Our Reference: 21_82_CPPL_EDCP_DD

Subject: 1111-1141 ELIZABETH DRIVE SUBDIVISION, CECIL PARK (SSD 8859) ACCESS REVISED DESIGN

Appendix A – Revised Access Design

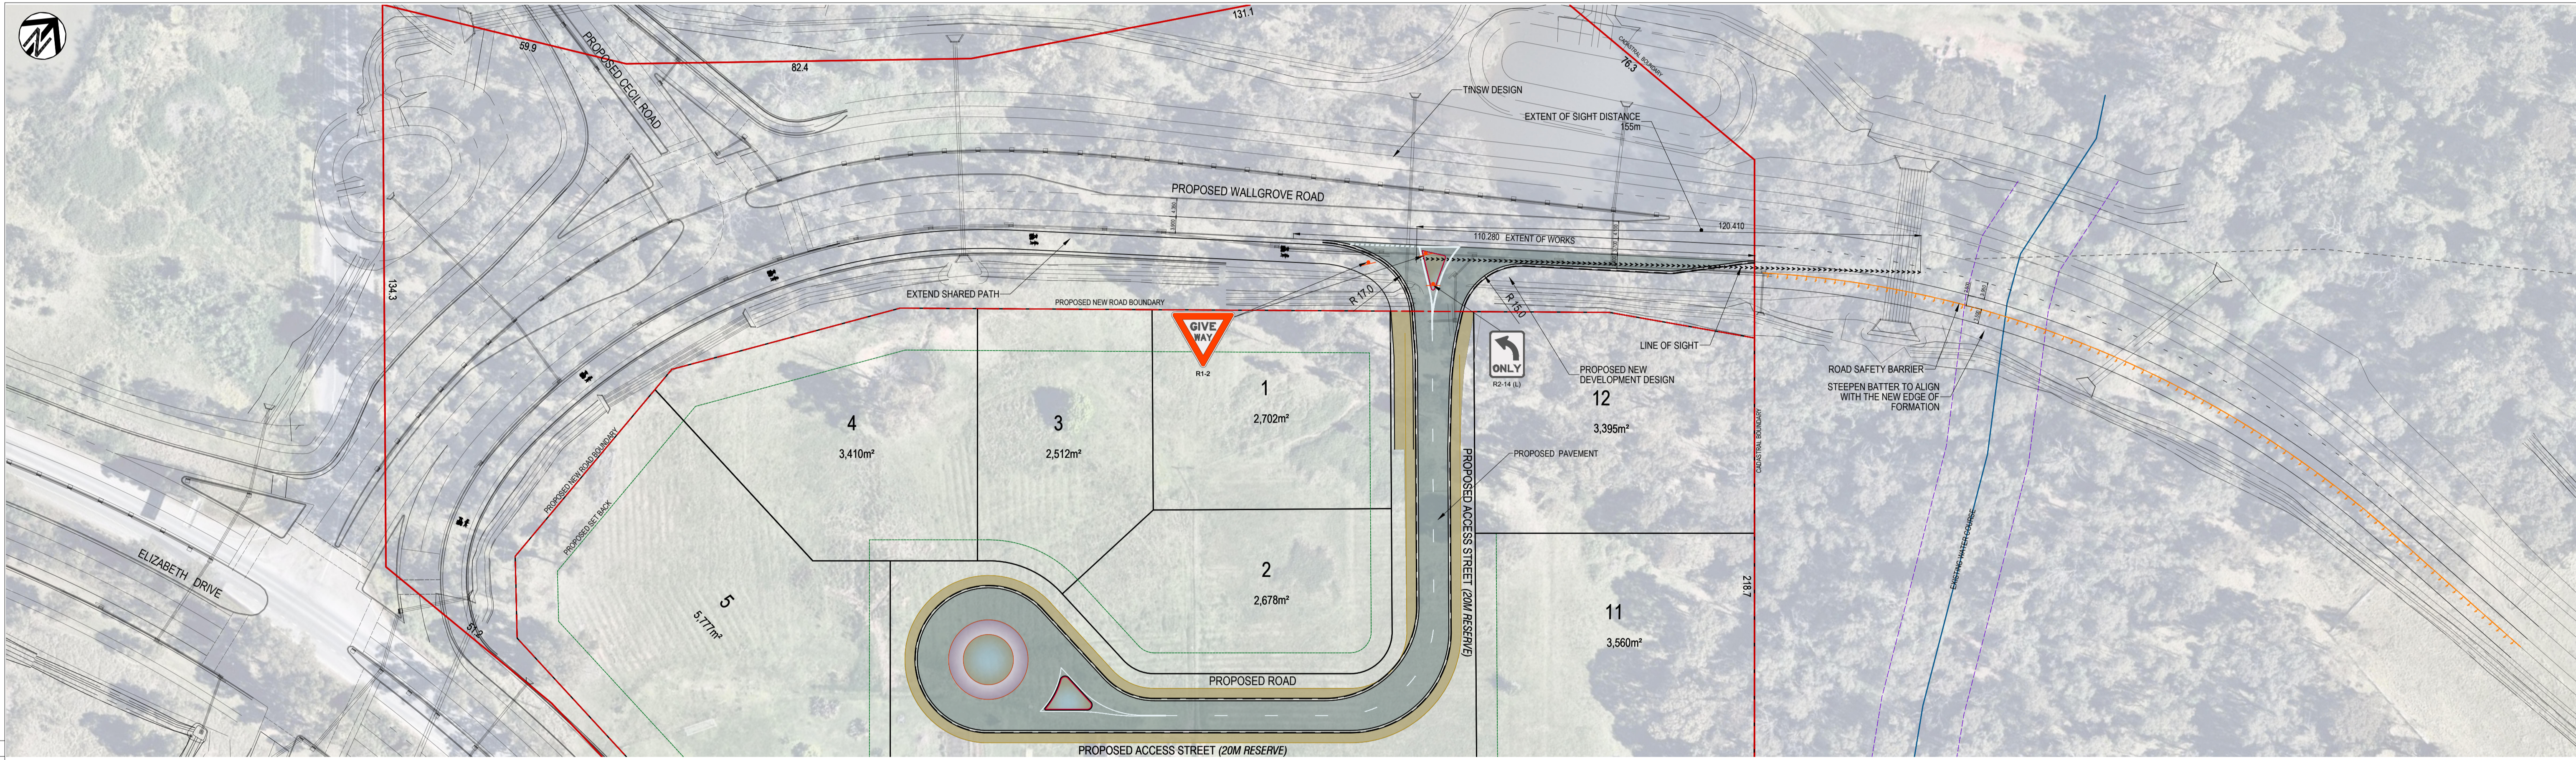
TfNSW Review Comments	MU Group Response
<p>1. There is a safety issue of the arrangement of the development of the second kerb side lane and the proposed left turn deceleration lane.</p> <p>Vehicles exiting the access road could confuse vehicles changing lanes to access the second kerb side lane with vehicles wanting to access the left turn deceleration lane and could lead to accidents. TfNSW requests that the development of the second lane be moved further back to the north in Wallgrove Road to the short straight between the reverse curves. The diverge should initiate from the centreline so vehicle continuing in the original lane is in lane one. The second lane should be fully developed prior to the second curve.</p> <p>The proponent should consult with M12 project team regarding the above for the best way forward.</p>	<p>TfNSW agreed that this is outside our limit of work. The development is constrained by the extent of the property boundary.</p> <p>It was agreed with TfNSW that this will be accommodated by the M12 project team.</p>

<p>2. The length of the left turn deceleration lanes is too short for the design speed of Wallgrove Road. The design speed of Wallgrove as per design criteria for this section of Wallgrove Road is 70kph with a posted speed of 60kph. For a design speed of 70kph the length should be 70m (including taper) with a turn speed of 20kph.</p> <p>As there is no development in the adjacent property and will be kept within the road reserve the length should be increased to be complying for the design speed.</p>	<p>The deceleration lane has a design length of 60m. It is noted that Austroads, Part 4a, Section 5.2 Deceleration Lanes, requires a deceleration lane length of 60m based on design speed of 70km/h and exit speed of 30km/h.</p> <p>The exit speed of 30km/h was adopted as the design has allowed for a left turn radius of 20m, which equates to an exit speed of 30km/h as per Austroads Table 5.2 and Figure 5.2.</p> <p>TfNSW indicated that this approach is acceptable based on the constraints and posted speed of 60kph.</p>

<p>3. Assuming that a second lane will be introduced prior to the auxiliary lane, the proponent will need to demonstrate that appropriate sight distances (AUSTROADS) are achieved to the C1 line.</p> <p>A preliminary review of the design suggests this to be problematic. Note the design will be providing a G4 W Beam to protect the 2:1 batter. Given the downgrade on approach, the sight distance over the barrier may be achieved but this would need to be checked. To achieve compliance the length of auxiliary lane will need to be extended, else the verge and batter widened out which may result in works occurring outside of the project boundary.</p>	<p>The sight distance assessment achieves a clear sight distance of 145m measured</p> <p>It is noted that Austroads Table 3.2 indicates a SISD of 141m for a reaction time, Rt, of 1.5 sec (the Rt satisfies the TfNSW supplement to Austroads Part 3). The assessment is also based on a driver height and observed height of 1.1m and 1.25m respectively, whilst the barrier height is expected to be at approx. 0.9m. The location of the barrier is yet to be confirmed through a 3D design model.</p>

6. The plan should be amended to remove all the chevrons in the entry and exit as it will get scrubbed out and it also entices pedestrians/cyclists to stand in the actual access.	The chevrons have been removed in the revised design. Further refinement of the line marking can be addressed in the detailed design phase.

7. The "No Access to Cecil Road" signs should be removed as it would be difficult to enforce.	The signposting has been removed in the revised design. The OTAMP can be conditioned for the development to develop prior to operation.
An Operational Transport and Access Management Plan (OTAMP) should be developed for the proposed subdivision to manage this arrangement.	TfNSW agreed that further adjustments to signposting can be addressed in the detailed design phase.

8. It is not clear why turning path has been provided for a B-triple (35.4m). NSW Freight and Ports Plan used 30m Performance Based Standards (PBS 2B) combinations as the target vehicles. The use of the B-triple requires the access to be wider than needed and lengthens the crossing distance for active transport users. As previously advised, PBS 30m vehicle should be used as checking vehicle.	<p>For consistency with previous correspondences with TfNSW in May 2021 a similar 35m B-Triple was used as check vehicle on the access design.</p> <p>However, as agreed with TfNSW, a 19m semi has been used as design vehicle and 26m B-Double as check vehicle. These are reflected in the revised design.</p>

9. The proponent is requested to update the plans and annotate with some dimensions; lane widths, path width. Information on the RT bay and whether it is of sufficient length should be confirmed.	<p>Lane widths and path widths have been provided as shown in the revised drawings.</p> <p>Note that the lane widths were adopted from the TfNSW Wallgrove Rd design. Also, note that there is</p>

The revised design is attached as Appendix A. It should be noted that this design is a 2D general layout for the access arrangement and incorporates the future realigned Wallgrove Road design labelled "*Proposed Wallgrove Road-CAD file-M12EDC_DA_ACCESS*" provided by TfNSW in Nov 2021.
